From: MSN Service [REDACTED]
Sent: 17 July 2019 16:08
To: Zac Denton <Zac.Denton@arun.gov.uk>
Subject: RE: M/45/19/DOC

Subject: M/45/19/DOC

Engineers Comments Regarding Condition 5- Surface Water Drainage

No. 93/16/05 X

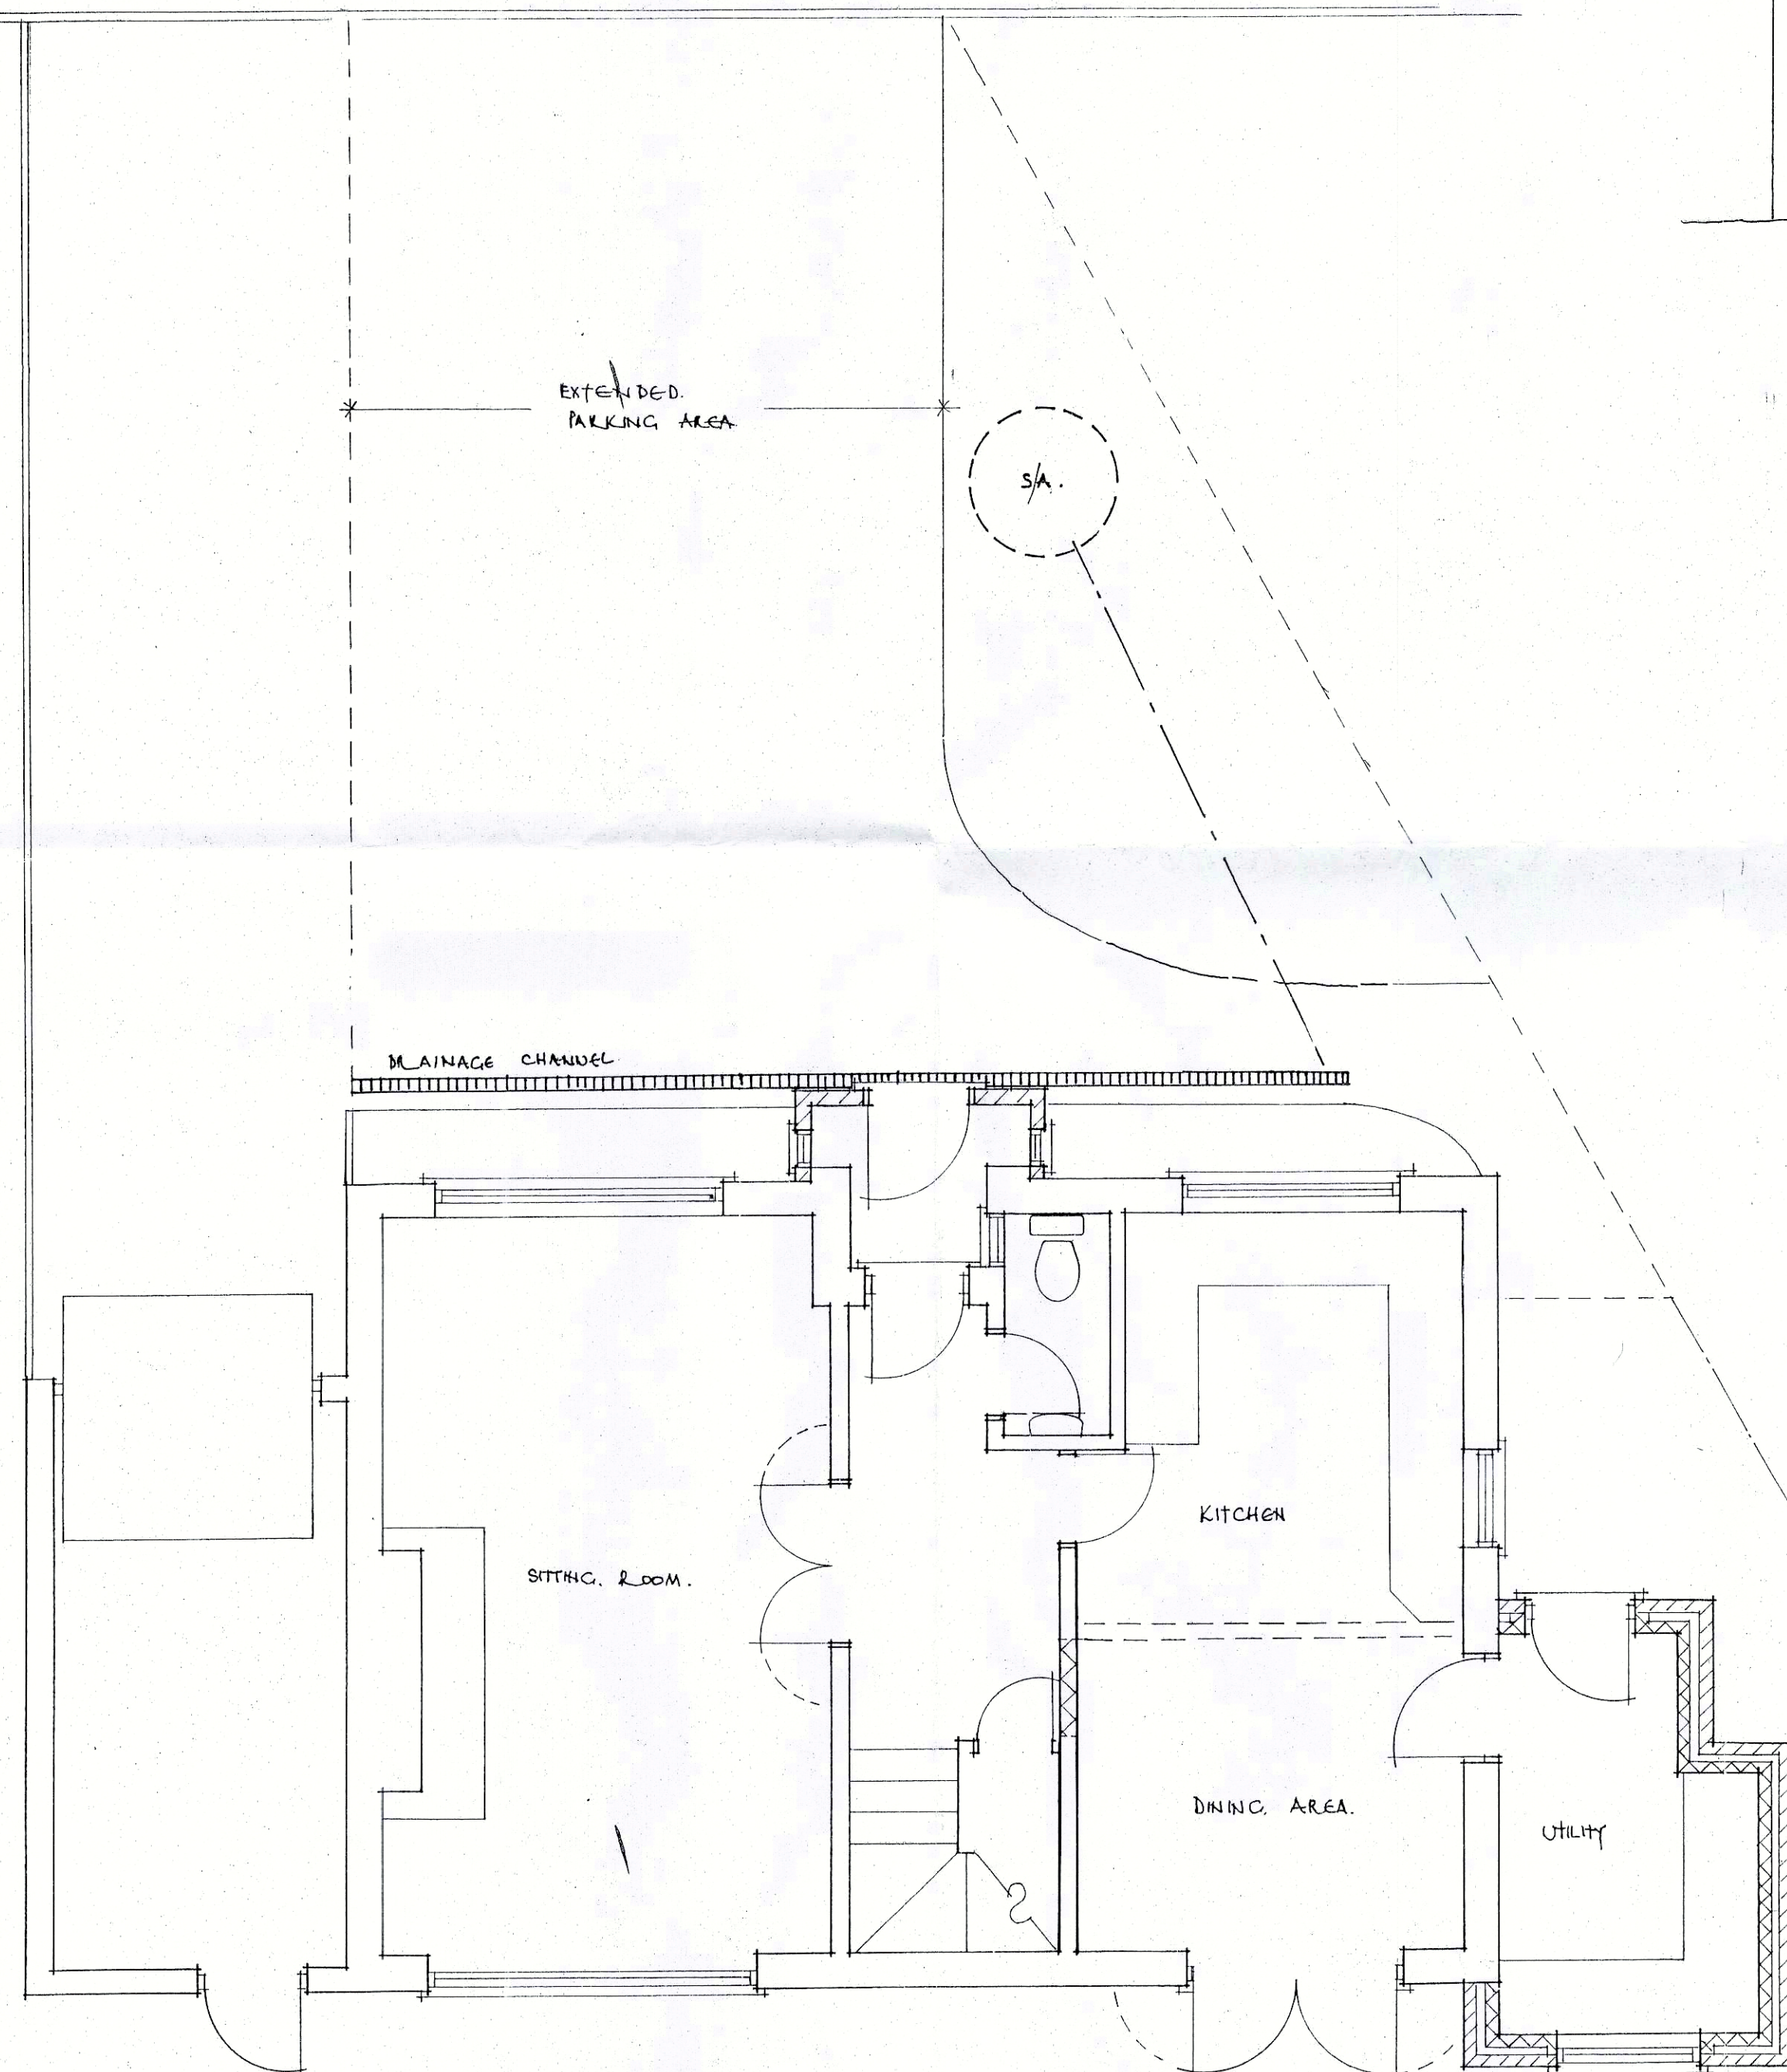
No groundwater monitoring, infiltration testing, calculations or details have been submitted.

Please can the applicant complete our drainage checklist (attached) and submit this with the supply of further information.
